TO: Kristy Martinez, Planning Department

FROM: Brandy Williams, Engineering Department

DATE: 5/7/20 (Engineering Received - 3/17/20)

SUBJECT: Aspen Ranch – Preliminary/Final Drainage Report SUBMITTAL #: 1

DESIGNED BY: CRD	SCALE: 1"=40'	DATE ISSUED: 3/12/2020	DRAWING No. RD03
DRAWN BY: CRD	HORIZ 1"=40'	SHEET 14 OF 78	
CHECKED BY: JAO	VERT. 1"=8'

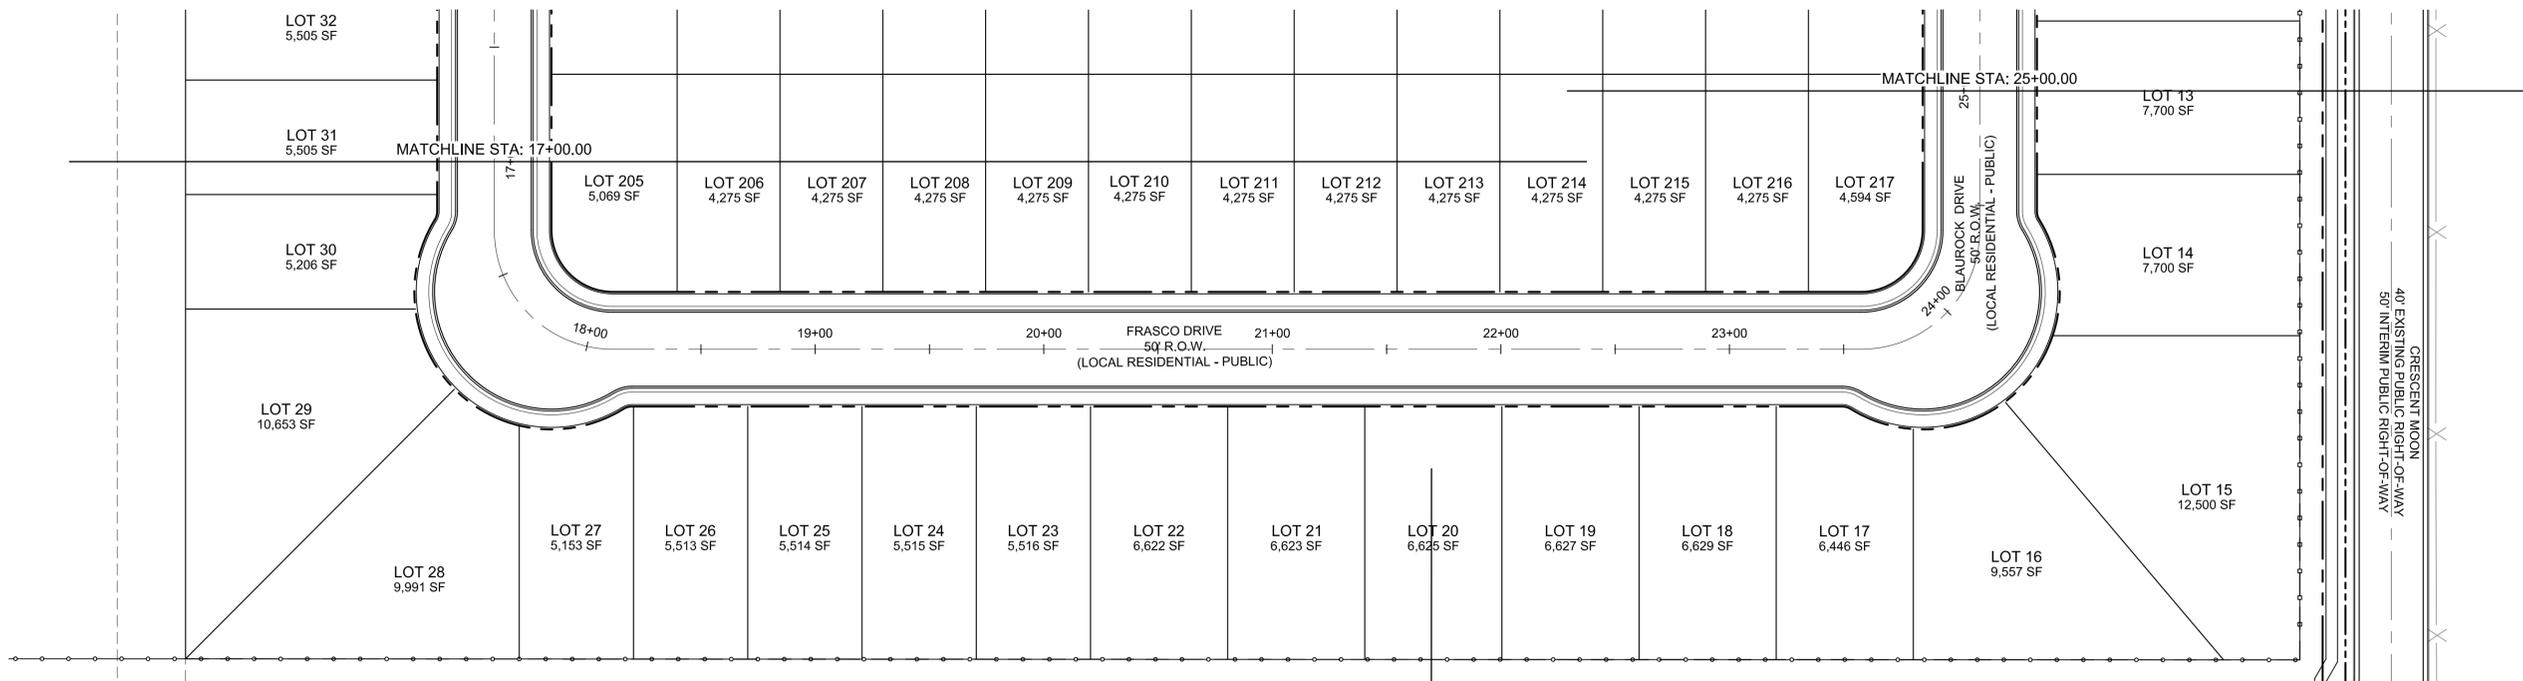
9. The rear portion of the lots of Castlebra should be included in basin B-5. **This appears to be the case as it is currently modeled.**
10. The front of the lots along Frasco Drive should be a part of basin B-2c. **This appears to refer to the north side of Frasco Drive. I believe that the basin is delineated correctly. These flows will run off the front of the lot and will flow west along Frasco then around the corner to Cronin which will convey the flows north to Design Point 13 in basin B-2b.**

GR01
 SHEET 11 OF 22

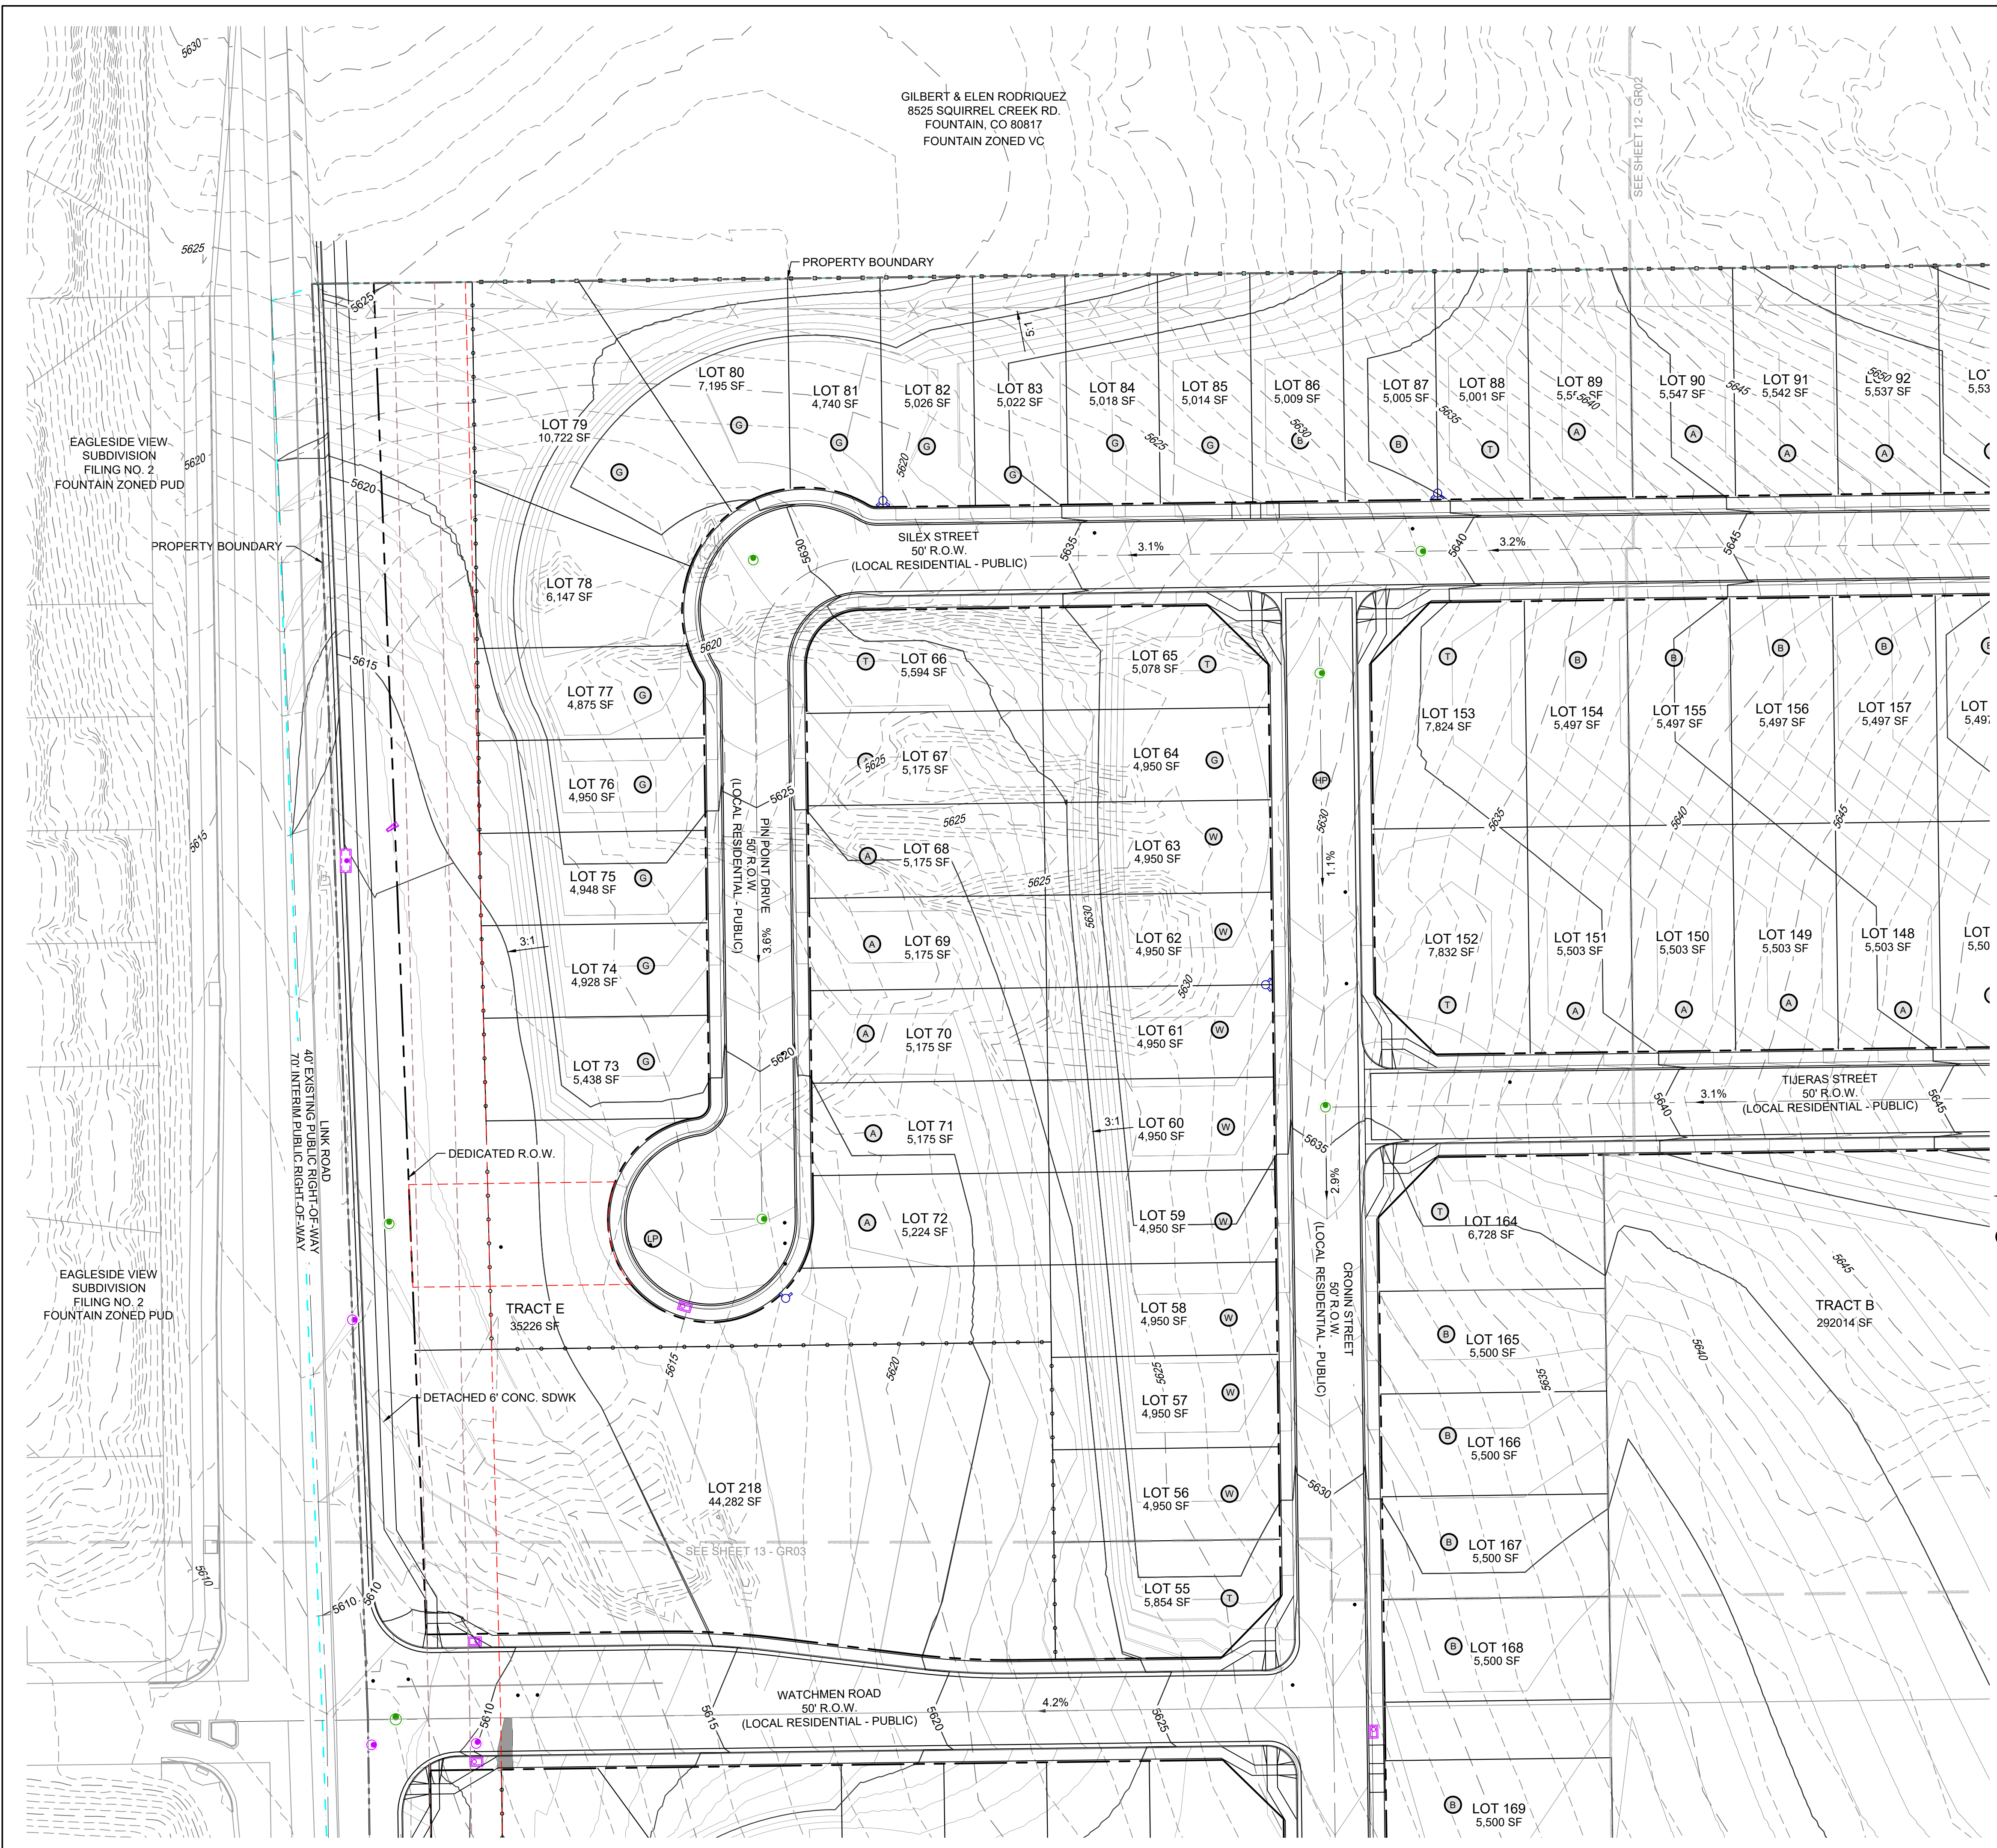
6. Quantify/route/mitigate surface and sub-surface flows in the southeast corner of the site coming from the Michael K & Joan Highland McNiece property. This area is to be analyzed and mitigated as directed by City Council. This is also a geotechnical report comment given to the Geotechnical Engineer to analyze this location. **An investigation of this item is in progress. Preliminary information from the first month with an FMIC irrigation water release event has been included. This initial information suggests that the FMIC irrigation releases drive the shallow water table at the south end of the site. The initial information also suggests that by providing a storm sewer bypass for the site and alleviating the ponding of water in the existing detention pond excavation, the development may mitigate much of or, at the very least, slow the increase to the water table.**
